Our ref:DOC25/956585

Your ref: SSD-10269-Mod-1

Narrabri Underground Mine Stage 3 Extension – Modification 1 – Request for Further Information

12 November 2025

Figure 3: Project Phasing for Offsets

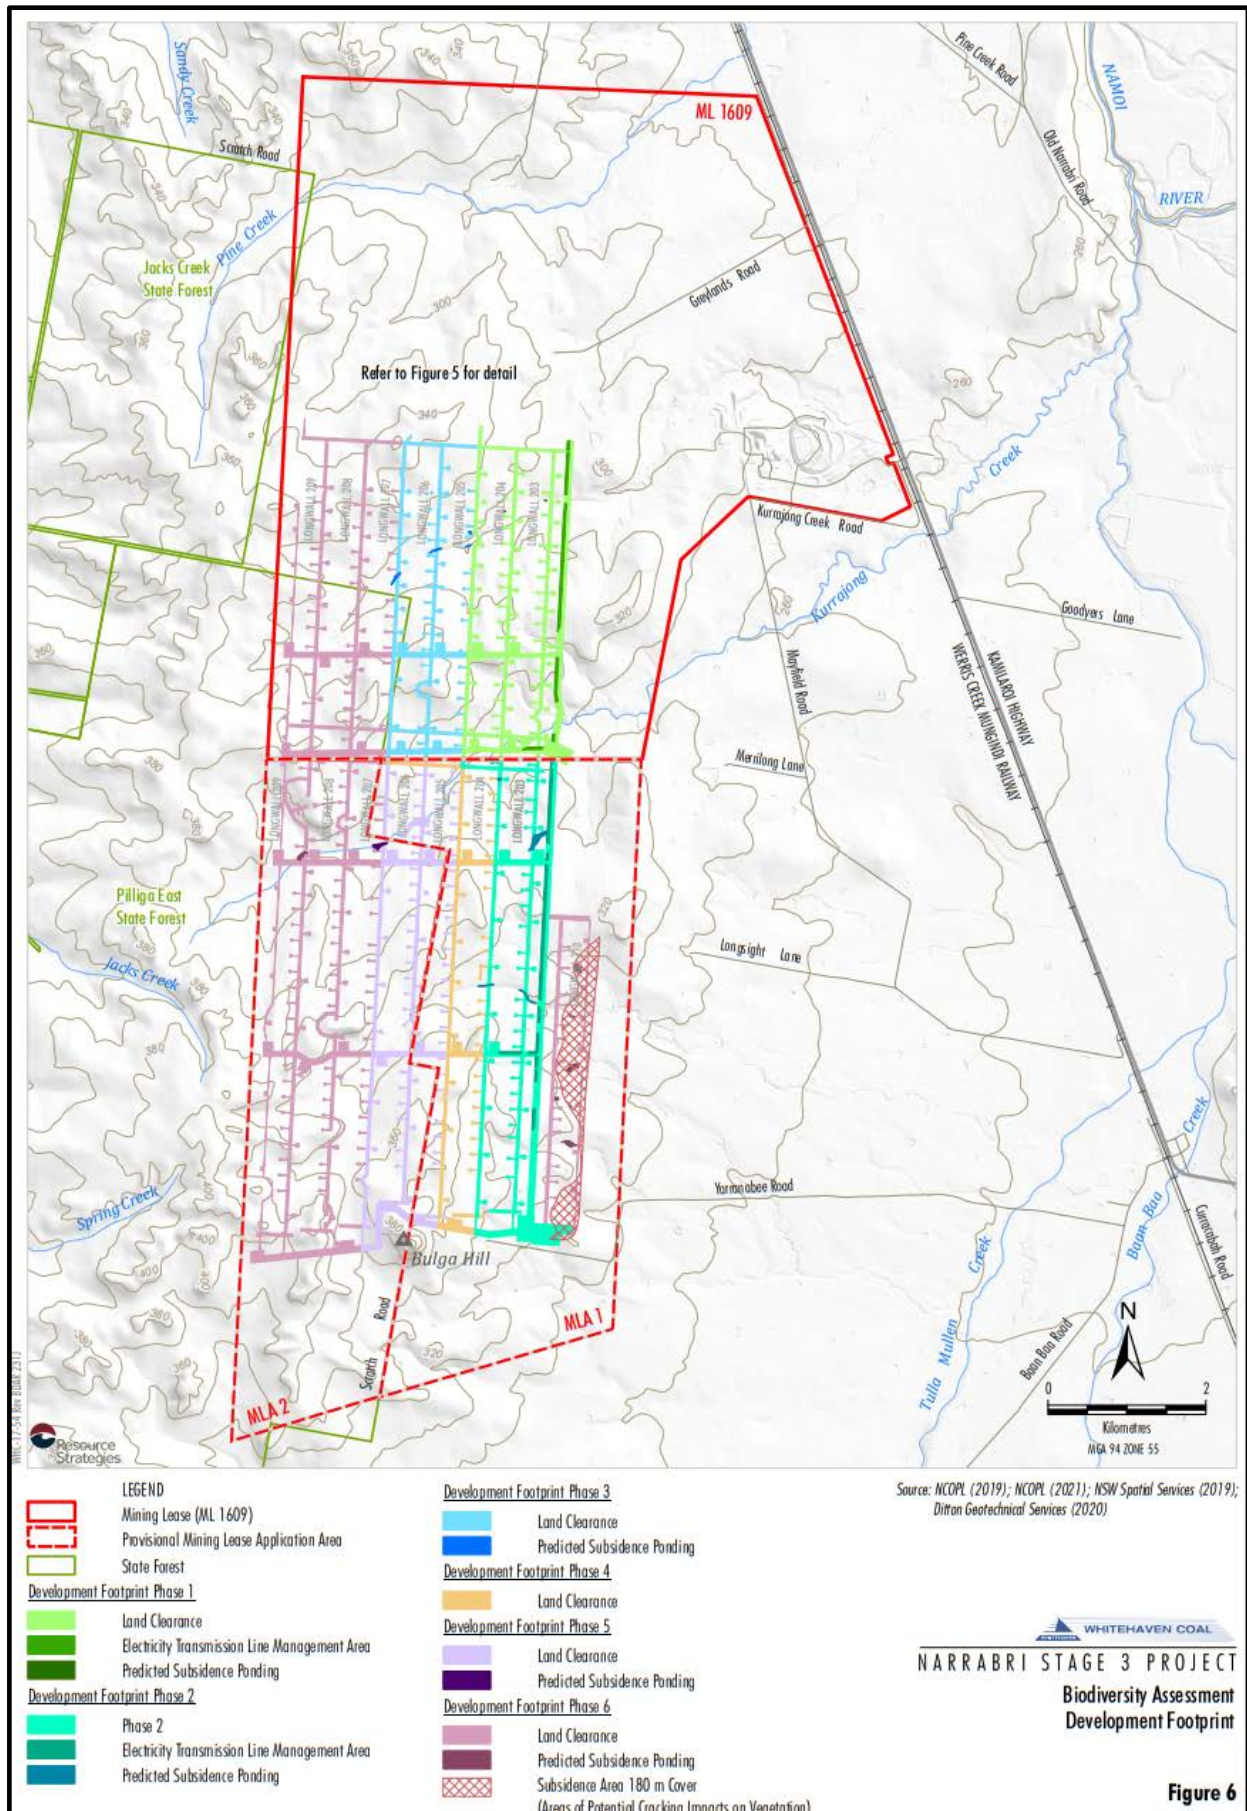
Following correspondence between CPHR, DPHI and the proponent, it has been explained that the RTS also introduces a new offsetting approach to proposed stages 6b and 6c. This involves aggregating subsidence ponding impact credits from Stage 6c into Stage 6b, effectively shifting credits from impact areas in the eastern portion of the project to an unrelated stage in the west (see Figure 1 below). The rationale for this approach is to ensure all ponding impacts are offset prior to their occurrence, as part of a conservative offsetting strategy. No operational requirements have been identified by the proponent to justify the need for this approach.

It is important to note that the requirement to offset Stage 6c prior to any impacts occurring would still apply, regardless of whether credits are shifted to an earlier stage. Whilst CPHR has no objection to the proponent choosing to pre-emptively offset impacts, the proposed redistribution of credits introduces a disproportionate level of complexity for the very small impact area it involves - 2.4 hectares, representing less than 0.4% of the project's total impact footprint.

Despite the minor scale of the ponding areas, redistributing and aggregating credits across unrelated stages will make tracking and auditing credit retirement increasingly difficult and time-consuming for both DPHI and CPHR. This complexity will be further exacerbated if credit retirement for stages 6b and 6c are later further modified under Condition B40 of the project's consent.

Given the absence of a clear operational need for the proposed credit redistribution, the disproportionate complexity it introduces and the fact that not redistributing credits would still ensure the project's legislative obligations are met, we recommend that the ponding impacts associated with stage 6c are not aggregated into stage 6b.

- 1.1 Credits for ponding impacts within stage 6c should not be aggregated into 6b.
- 1.2 DPHI note that there are credit errors in the MOD 1 report (dated June 2025) and the RTS report (dated July 2025). CPHR have replicated the correct credit calculations (excluding proposed aggregations between phases 6b and 6c) in **Attachment A**.
- 1.3 If DPHI consider accepting the proponent's proposal to aggregate credits, we would like to discuss a relevant condition with DPHI to ensure that the aggregated impacts in Stage 6b are offset prior to any clearing occurring within Stage 6c.
